Our ref: doc19/744007  
Senders ref: SSD 10339

**Subject: Notice of Exhibition: Prince of Wales Hospital – Addition to approved Acute Services Building for Health Research Use, Hospital Road, Randwick – SSD 10339**

**Senior Team Leader Planning  
Greater Sydney Branch  
Climate Change and Sustainability**

Title:
Prince of Wales Hospital, Hospital Road Lowering Stormwater Drainage Strategy, Probable Maximum Flood Impact - Developed Option

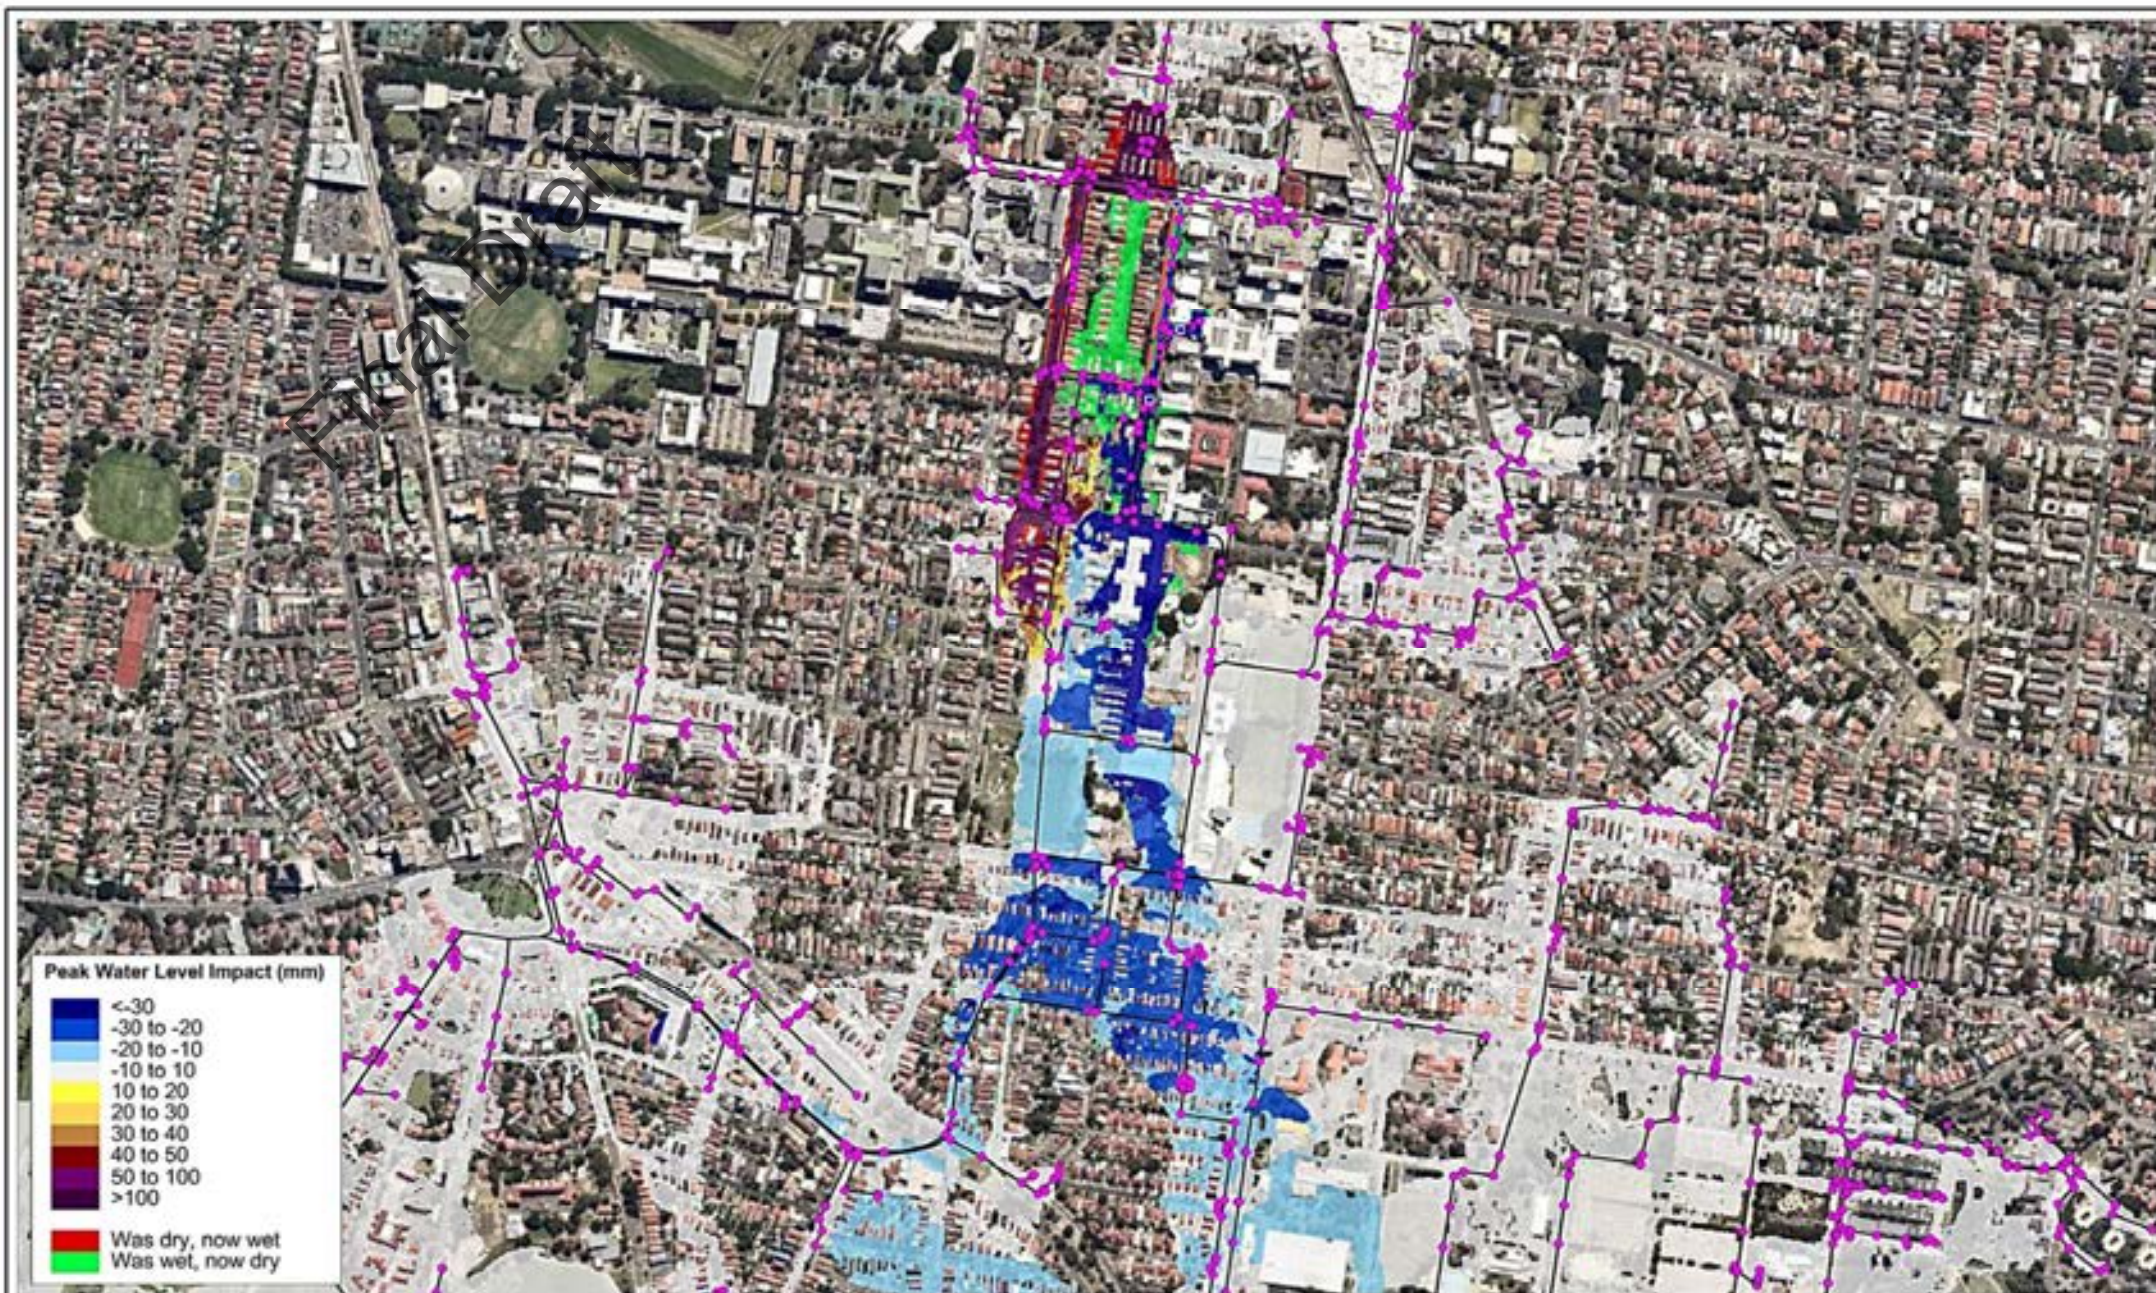
If the Department determines to grant approval EES recommends, though the proponent is not required to provide compensatory measures to mitigate the impacts of the project in events rarer than the design event (1% AEP), that the impact of the project on flood damages and emergency management planning should be assessed and consultation should occur with property owners and relevant councils in the early stage of the planning. This is recommended because Randwick Campus Redevelopment POW Hospital Road Lowering Flood Modelling (BMT, December 2018) shows significant increases in flood level of the PMF on some properties in High Street and Blenheim Street.
